From: [Jeremy Larson](#)
To: [Jeremiah Cromie](#)
Subject: RE: SI-23-00001 Manastash Estates - Notice of Application
Date: Tuesday, February 14, 2023 4:53:19 PM
Attachments: [22- SIGNS.pdf](#)

Please review the following Sign Permit application: SI-23-00001 Manastash Estates. Any comments **need to be submitted by 5pm on February 27, 2023**. Please let me know if there are any questions.

① Elevation: Pillar Sign  
Scale: 3/4

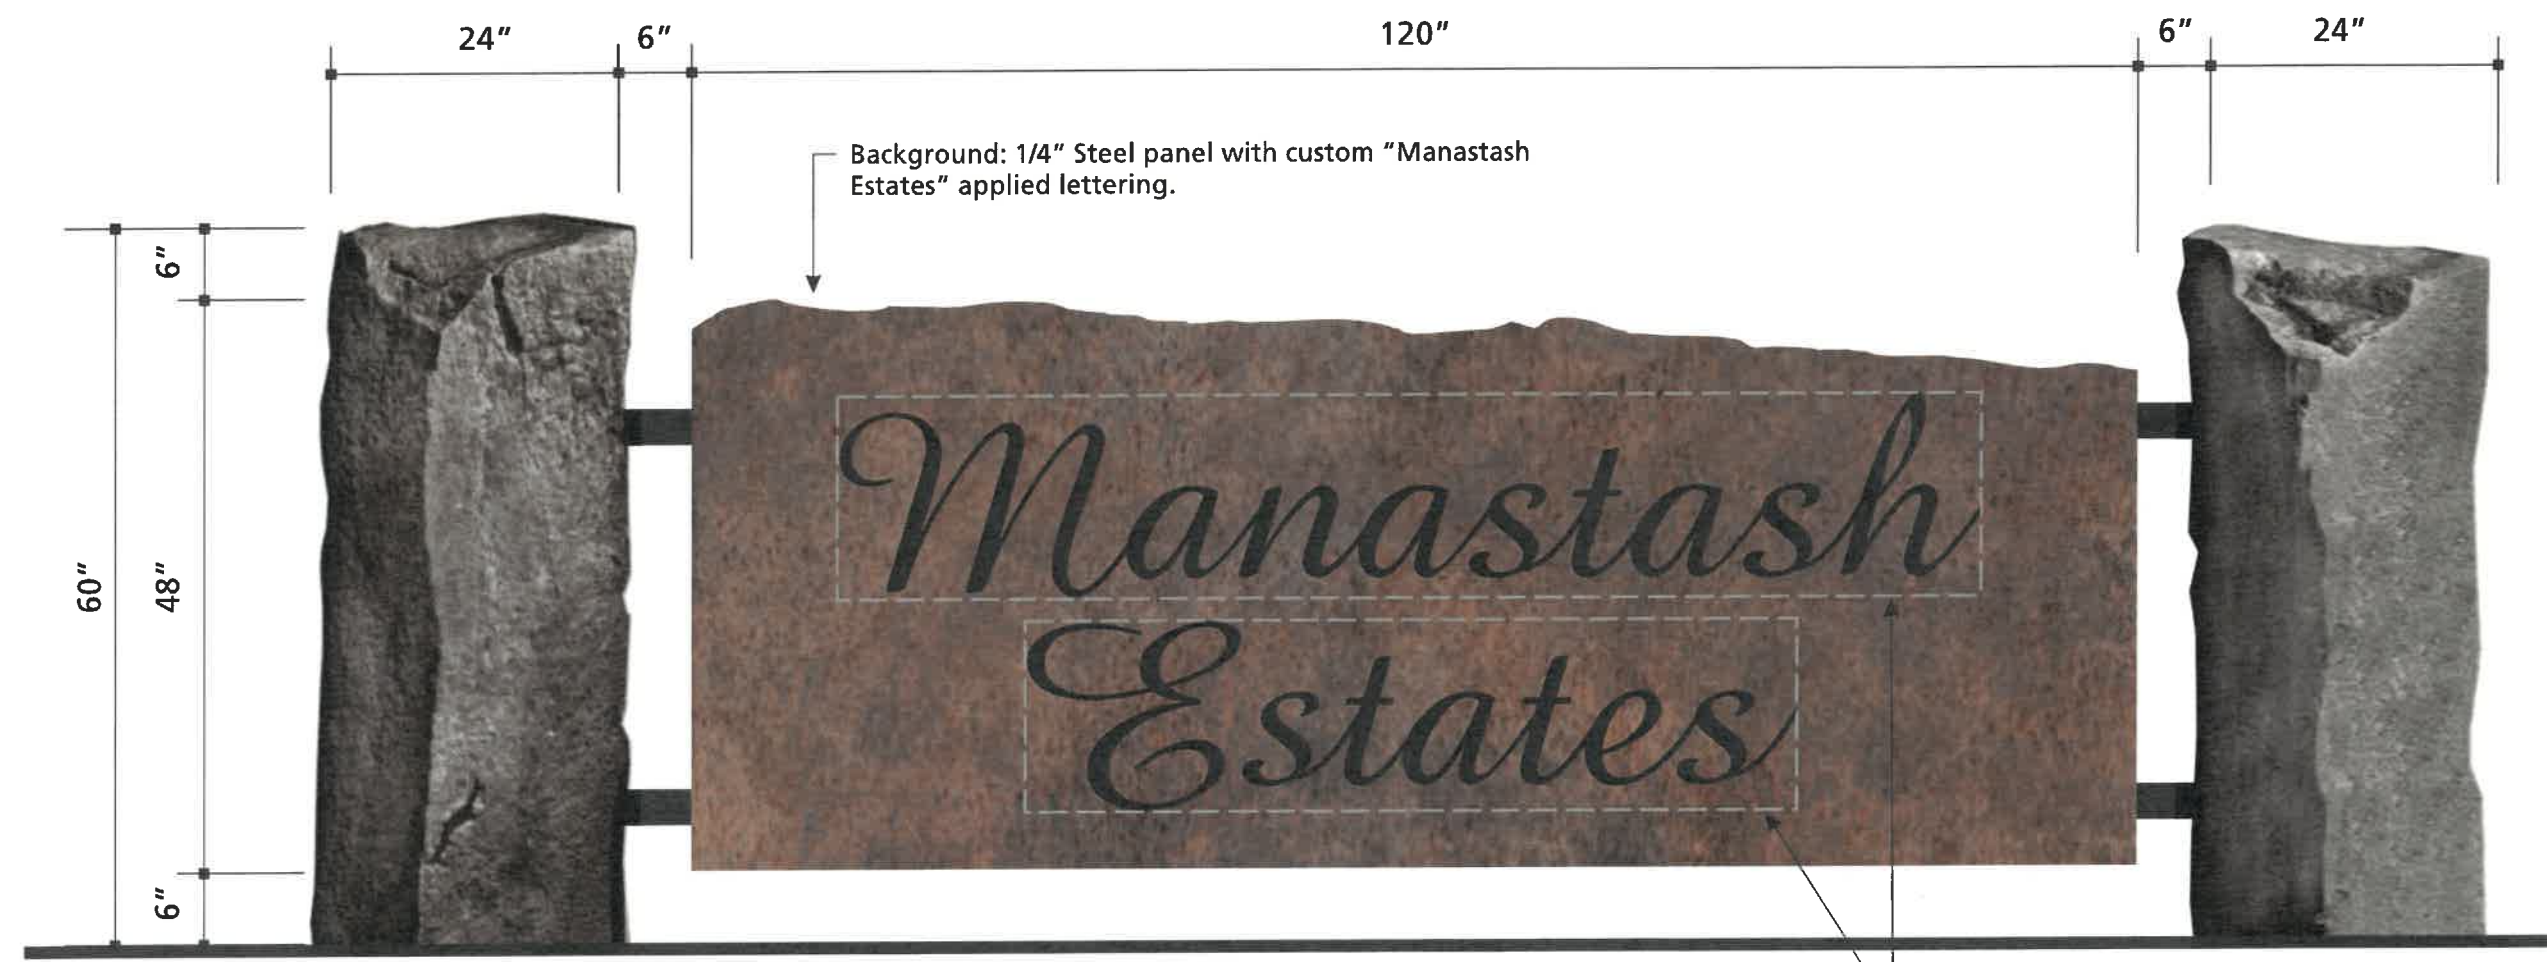
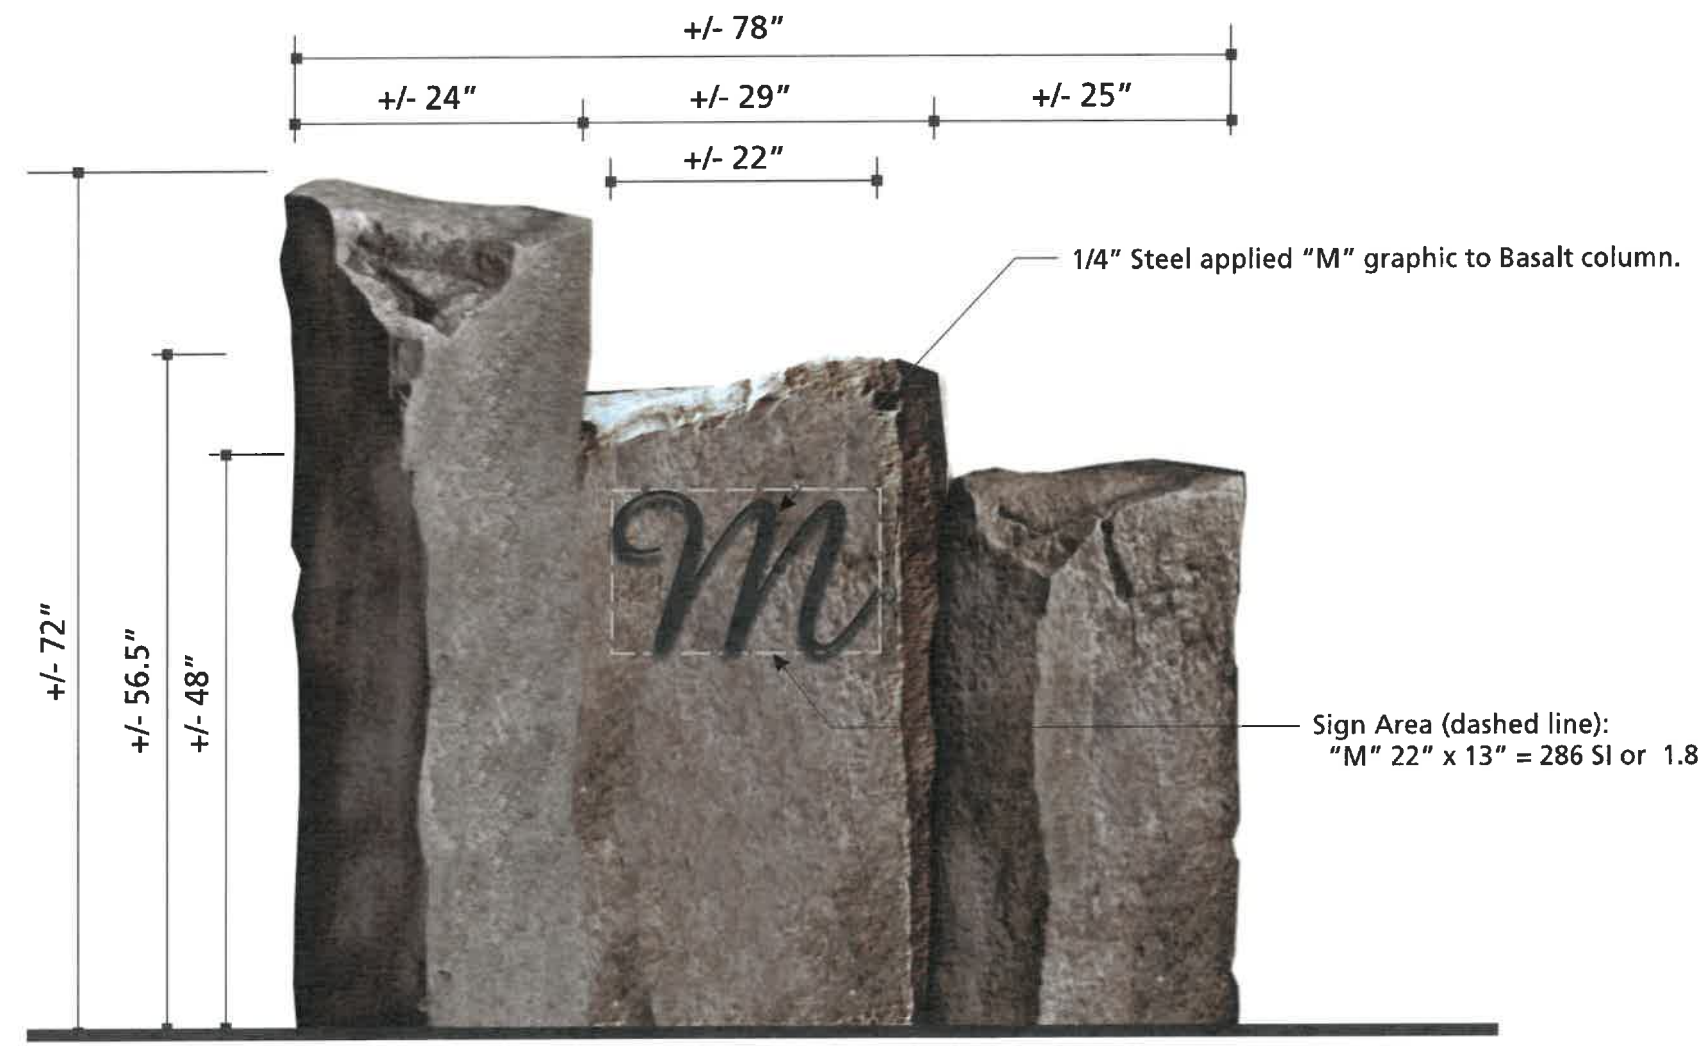
Thank you for your request for comment. Per Kittitas County CDS Sign Permit Policy (Item 22), a building permit is required. Additionally, due to the spacing of the posts being over eight (8) feet, the sign must be fully engineered. The Sign policy is attached to this email for reference.
